Your ref: SSD -10425  
File no: MC-20-00005

29 January 2021

**SSD10425: Stage 2 – Detailed Development Application - Tallawong Station  
Precinct South**

## Blacktown Council's requested conditions of consent to SSD 10425: Stage 2 – Detailed Development Application - Tallawong Station Precinct South

PLAYGROUND LONG SECTION SECTION B

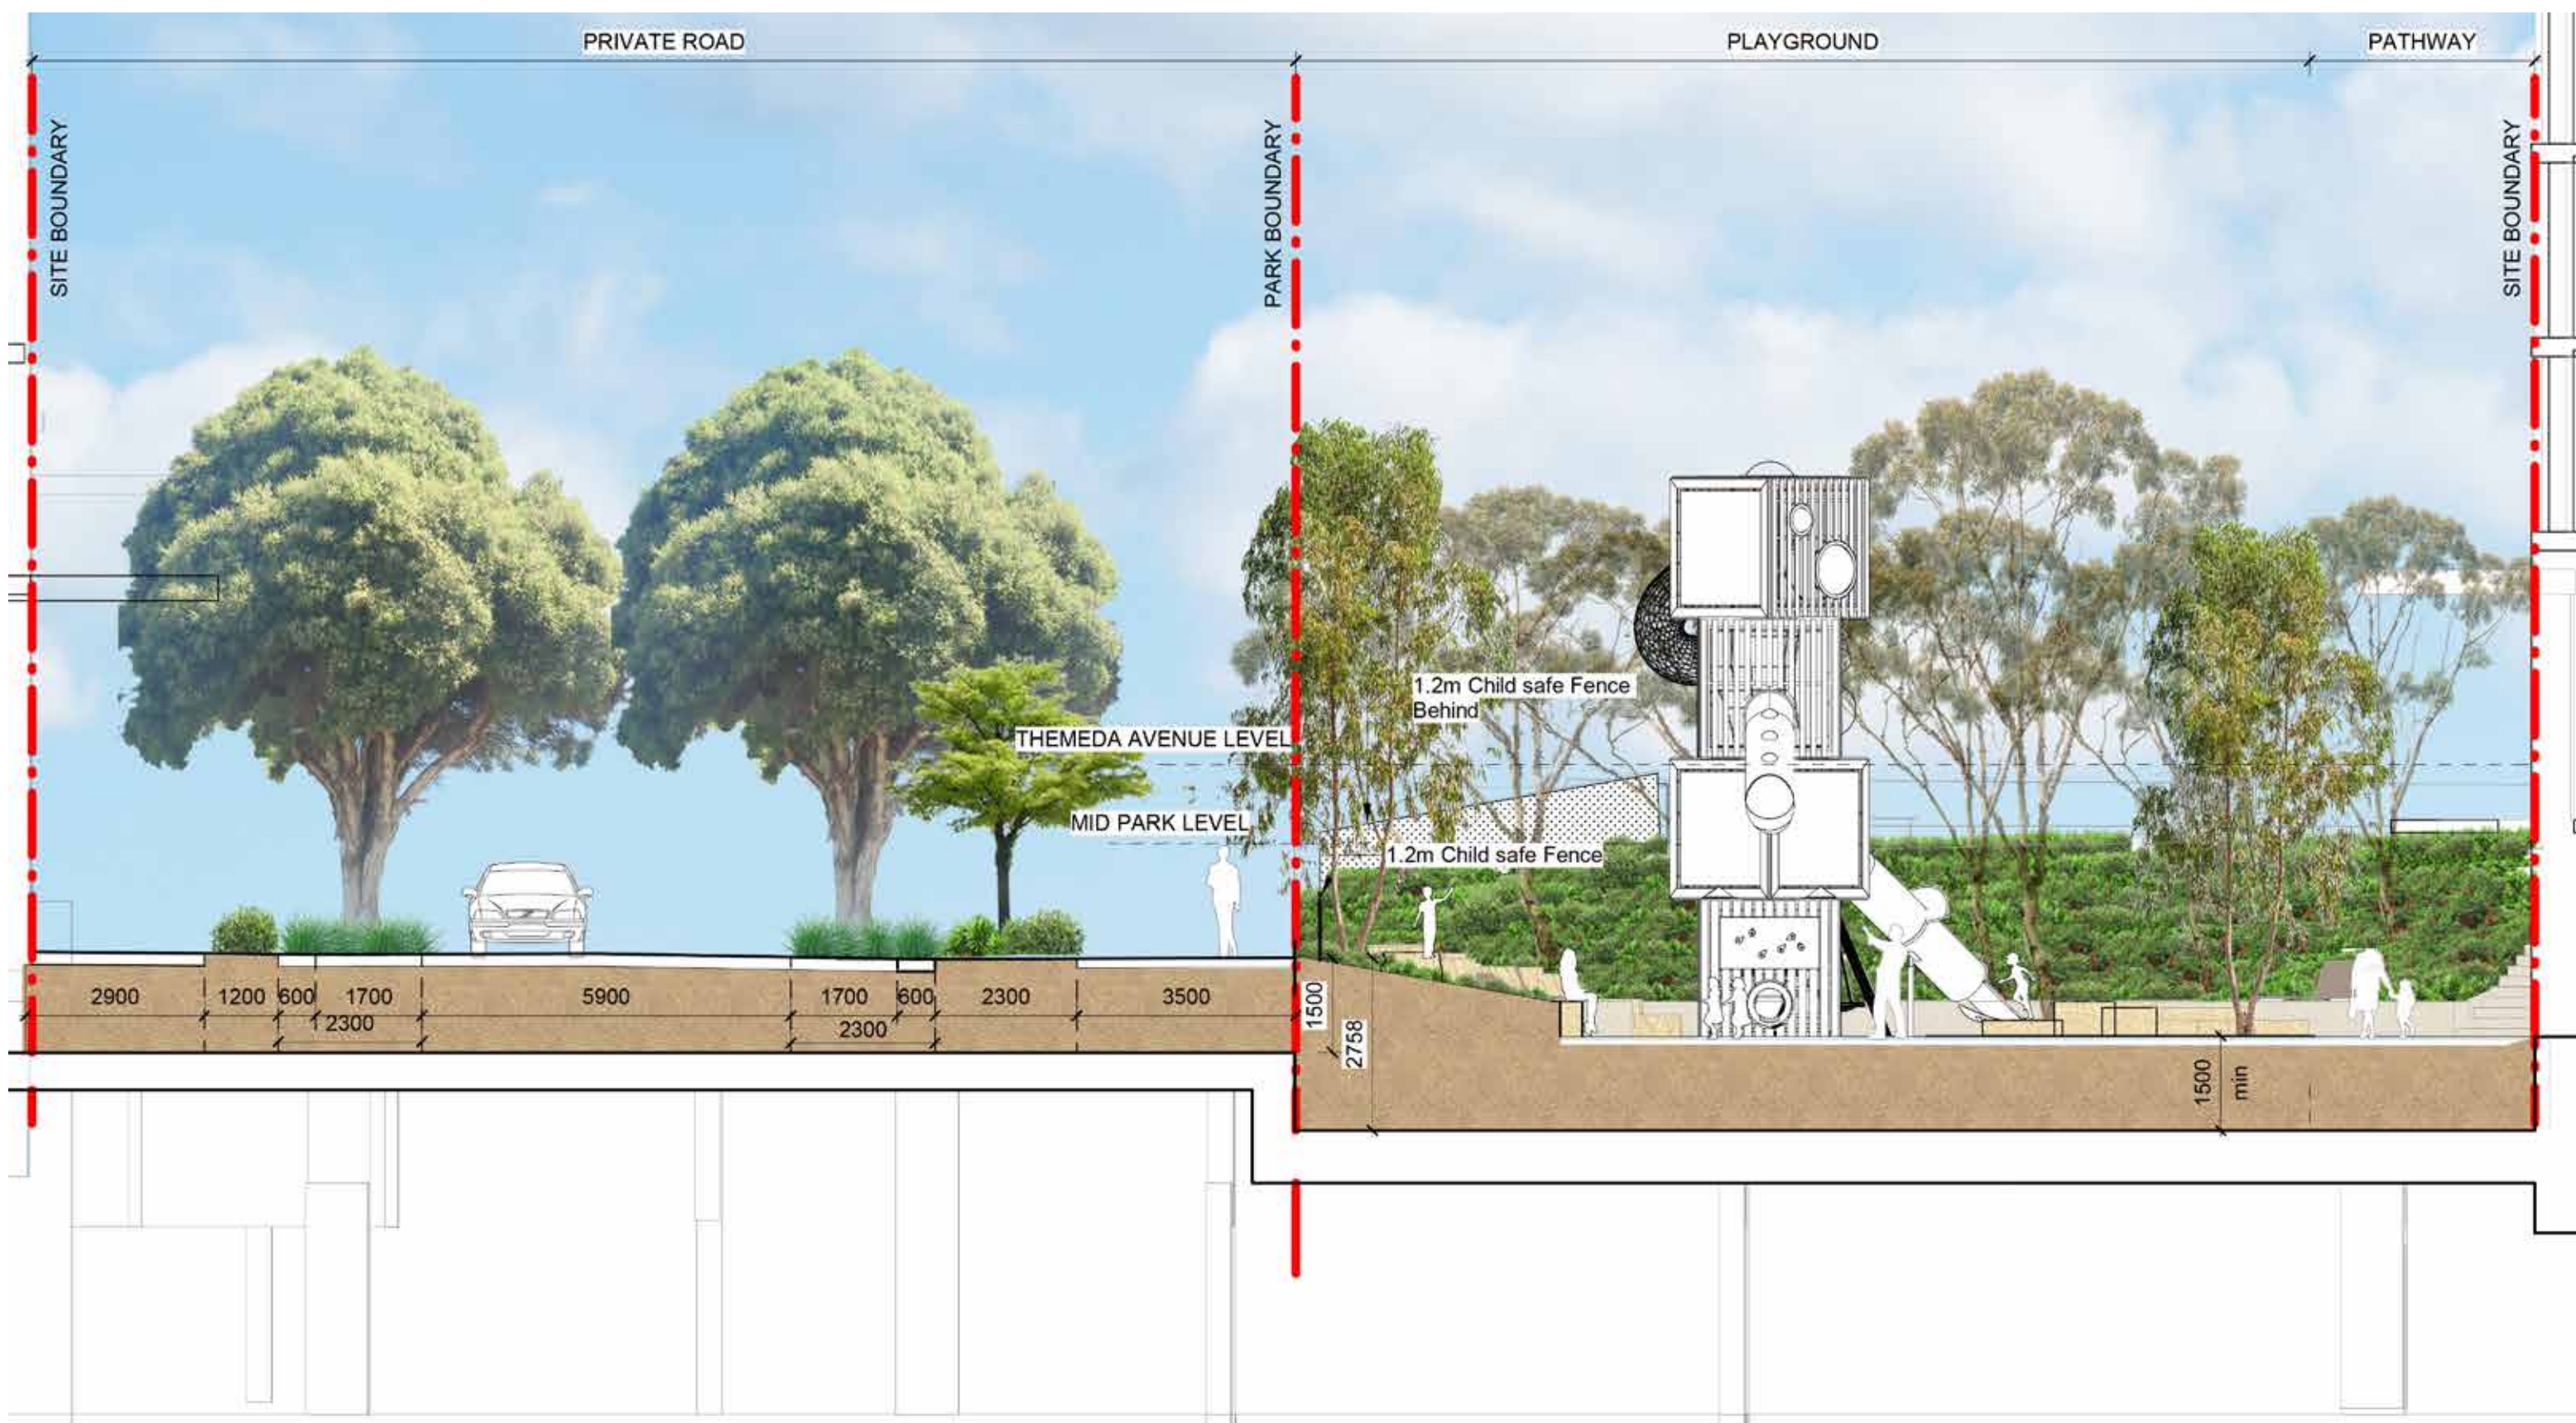
- Design out the need for the park gate. The gate is too close to the inclusive carousel and wheelchair circulation will be impacted while the park gate is operating.
- Provide signage in the park to advise the public of the land ownership and maintenance of the park.

3.1 The following matters are to be amended on the plan prior to the issue of any Construction Certificate:
